# **Aquind Interconnector**

## **Local Impact Report**

**October 2020**

Appendix 2 – Converter Station Access Drawing

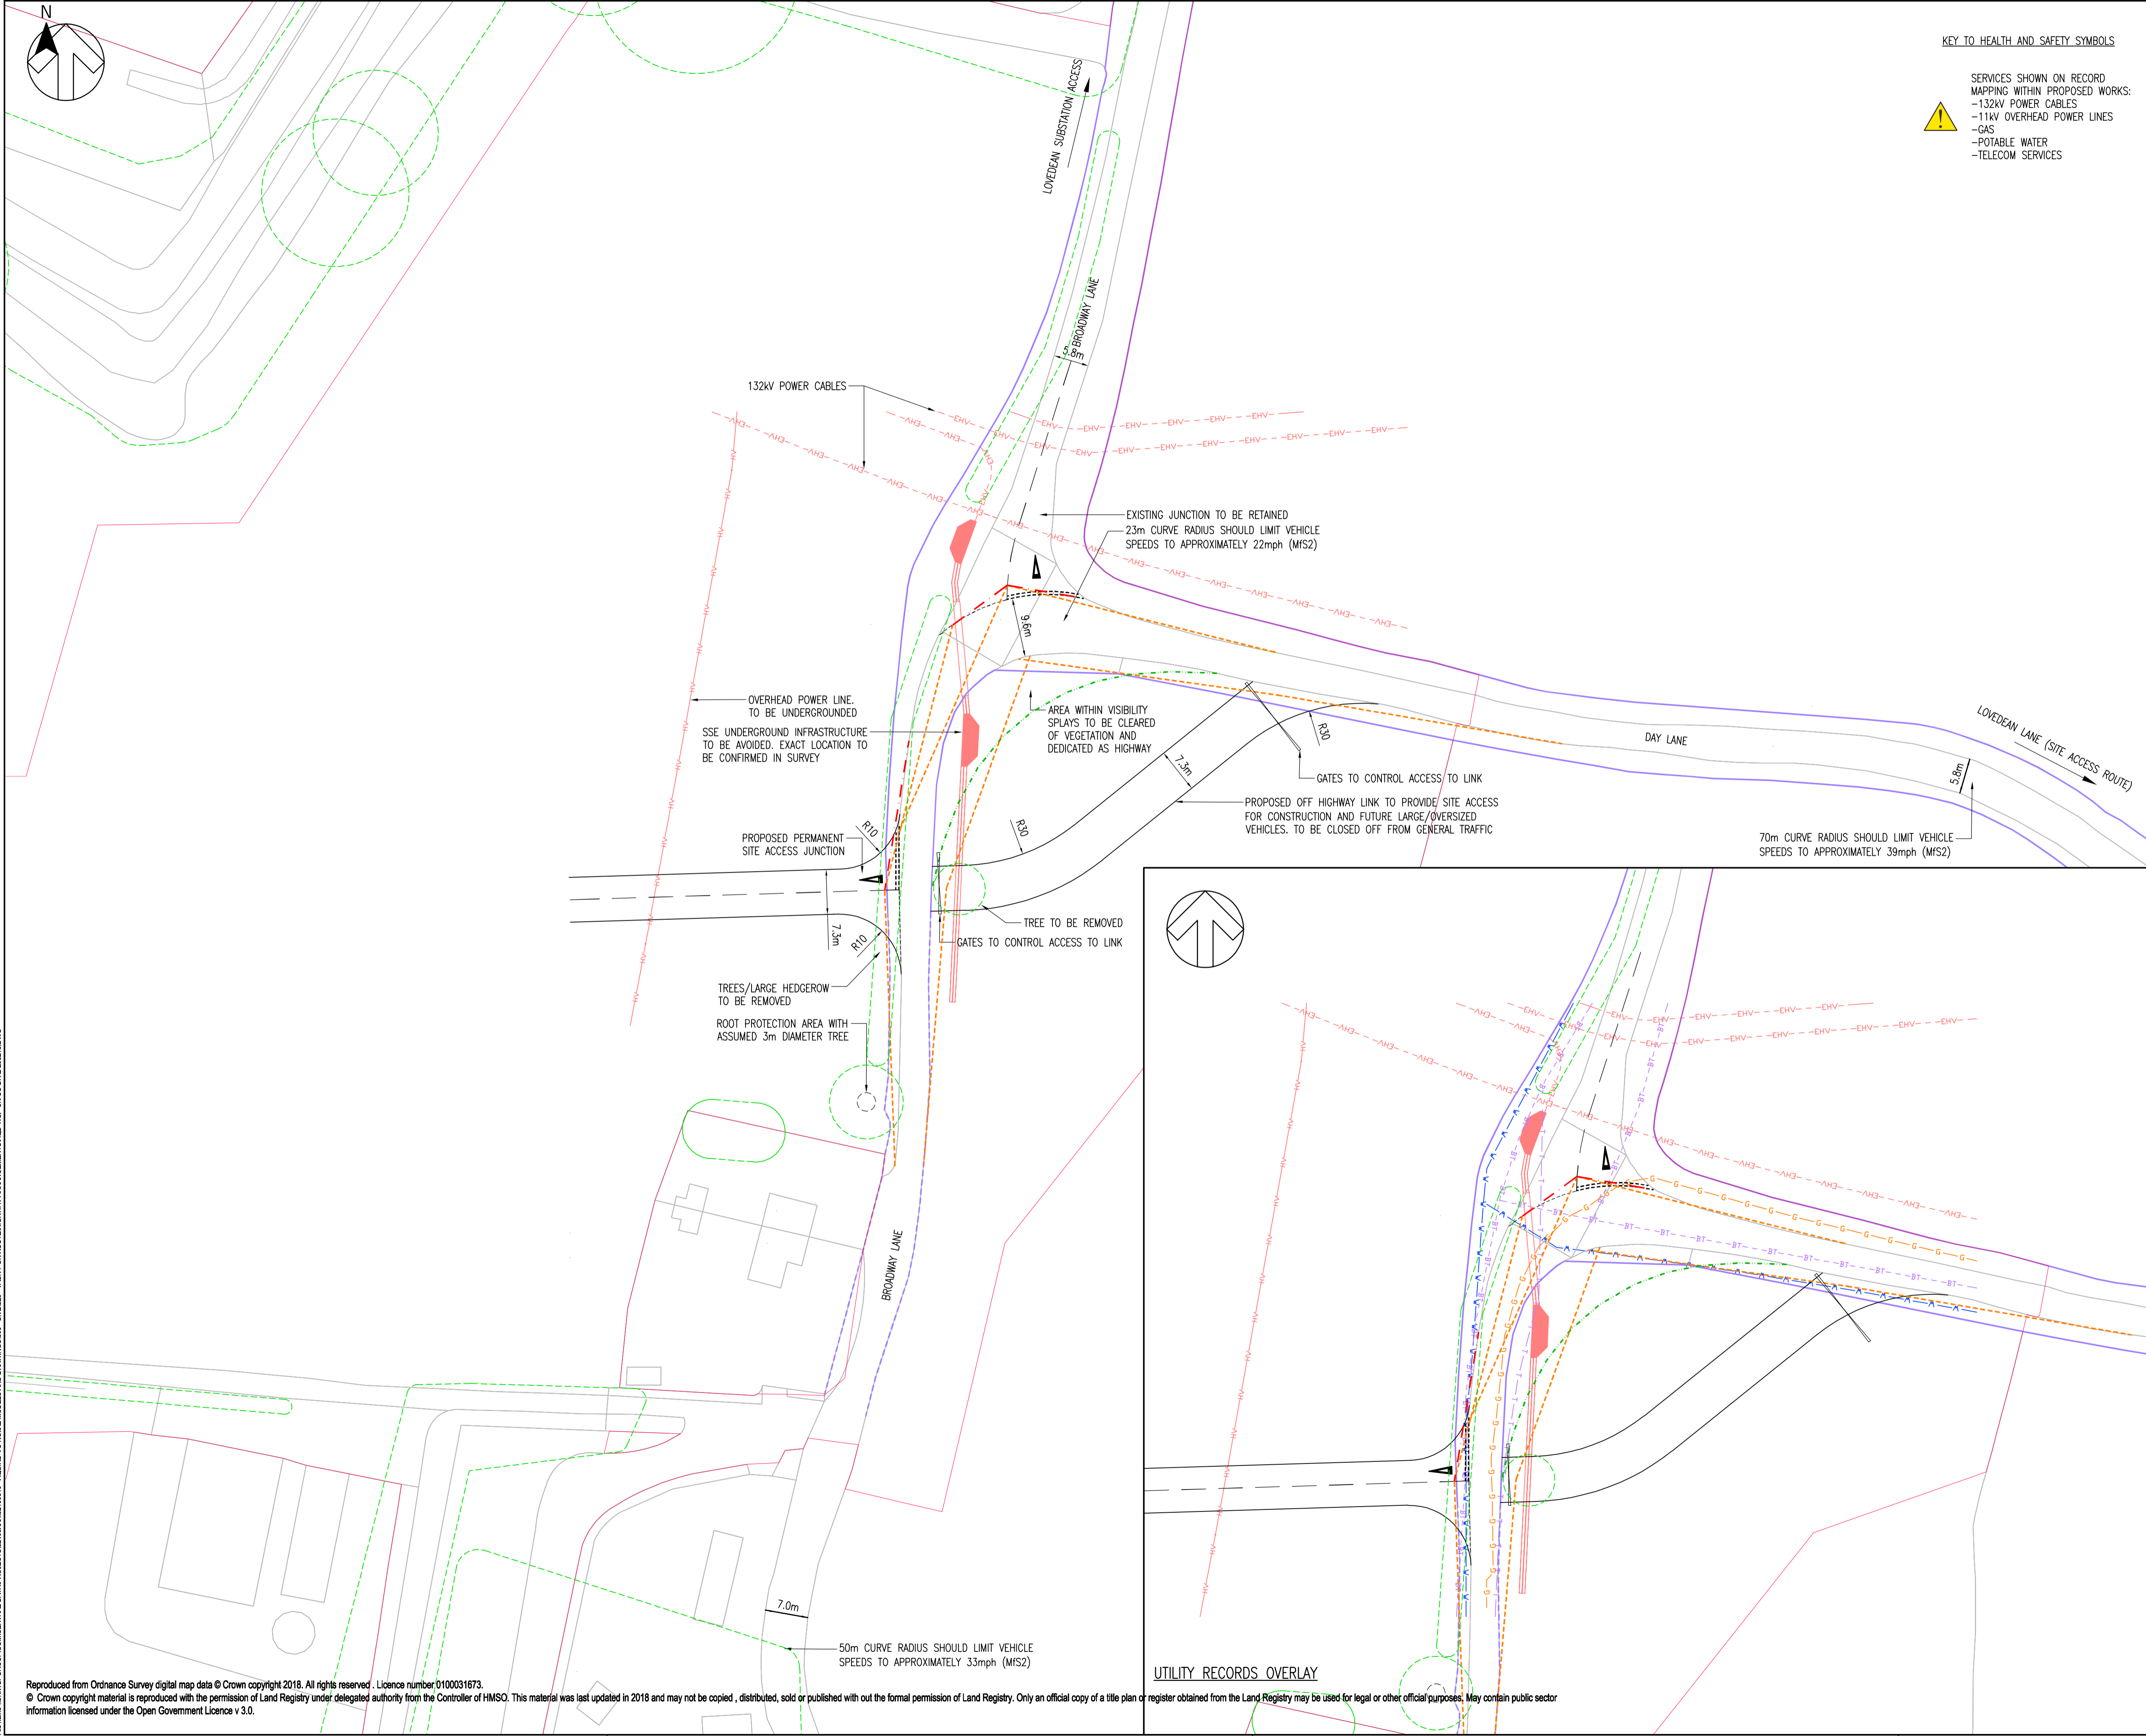
- 5.4.4 The long access track (1.2km long and up to 7.3m wide) will widen the extent of the land impacted by the development beyond the immediate confines of the proposed buildings (including providing a further urbanising access to Broadway Lane, which is currently rural in character).
